September 1, 2010

RE: Walker Boundary Line Adjustment, BL-10-00002 and Segregation SG-10-00014

Map Number: 18-19-08020-0011 Parcel Number: 814236

EXHIBIT

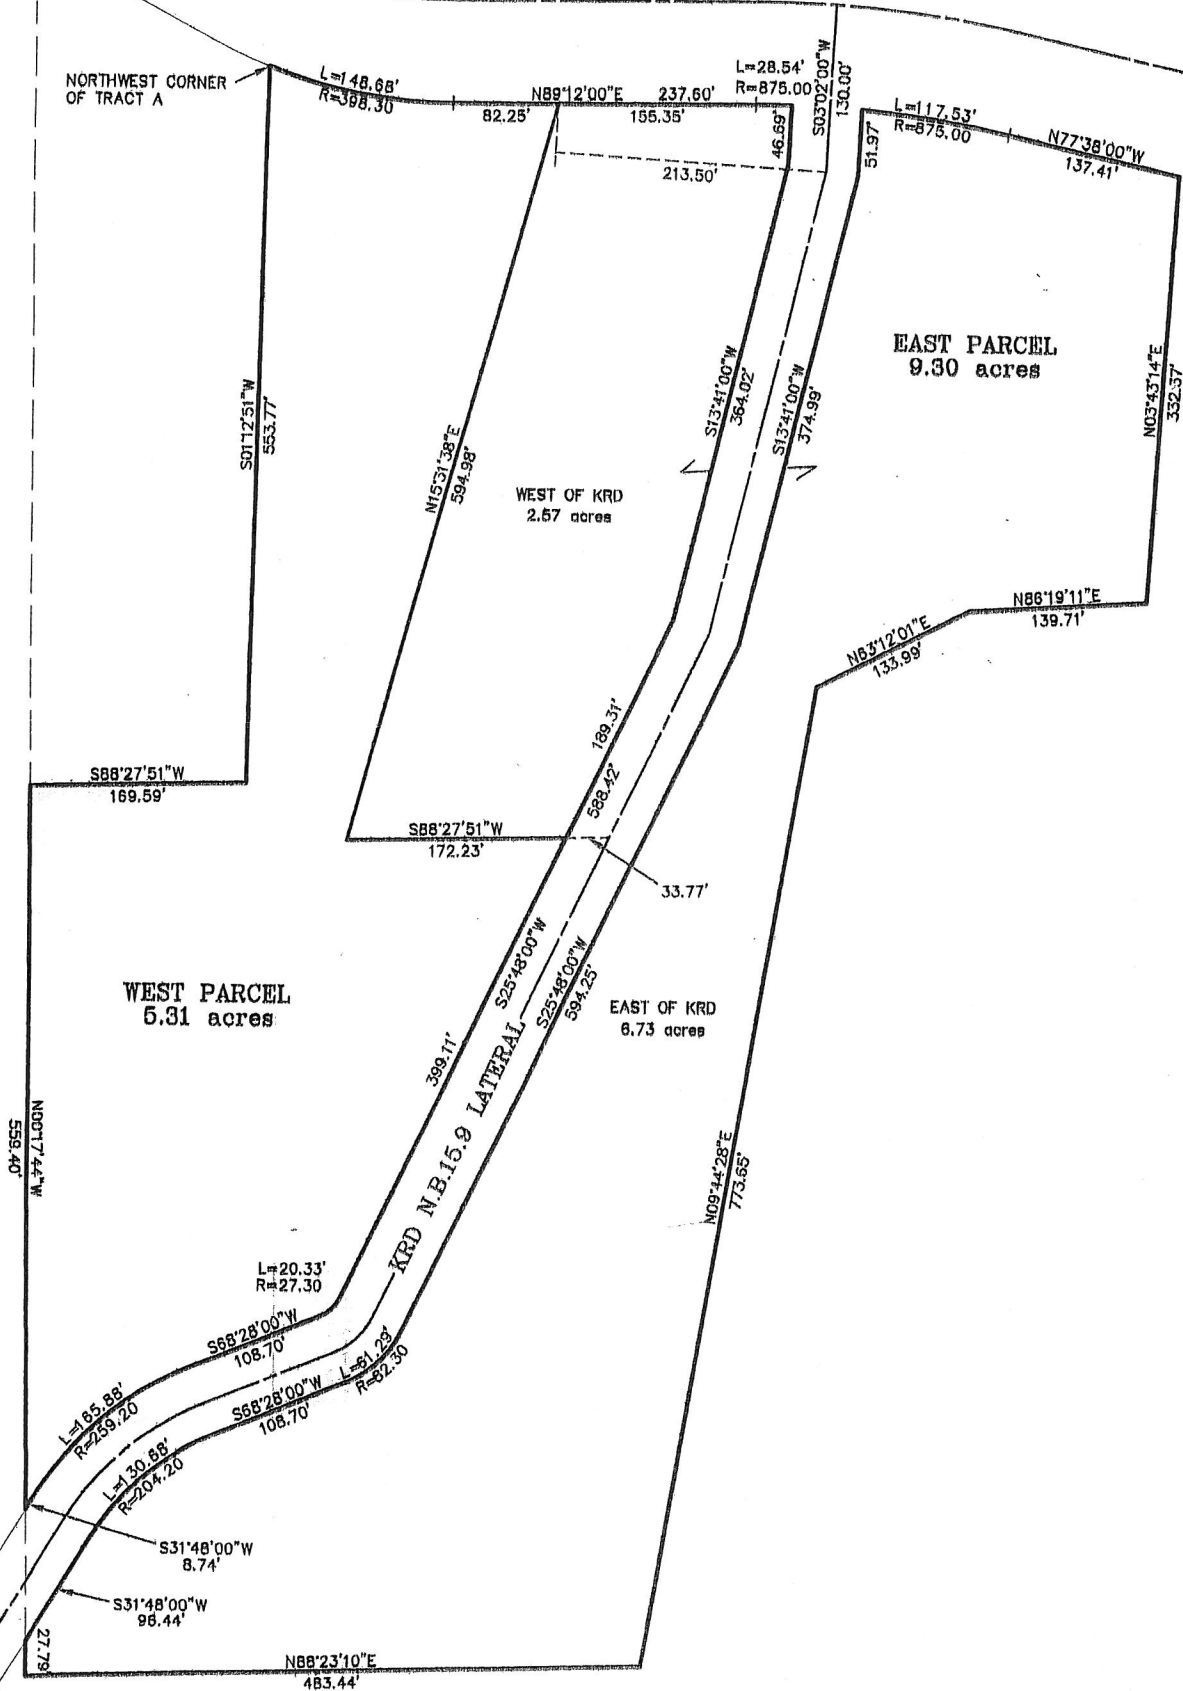
3. Wellhead protection areas KCC 17A.08.020; All non-community wells must be placed a minimum of 50 feet from property lines. OSDS Location KCC 13.04.080; Septic tanks must be located 5 feet from the property line, and disposal areas at least 10 feet from the property line. **The proposed BLA appears to be in the near vicinity of existing structures and improvements. Please indicate on a site plan or the survey existing well and septic locations with their proximity to proposed lot lines.**

4. These properties are within the boundaries of the Kittitas Reclamation District. The applicant will need to comply with all KRD requirements prior to final approval of the Boundary Line Adjustment. **KRD has indicated that "All of the KRD irrigable acres are on the parcel west of the KRD lateral. If this configuration stays, the KRD general guideline will not need to be met at all of the KRD acres will stay on that piece." Please clarify with them the final configuration and nature of the conditions if any.**
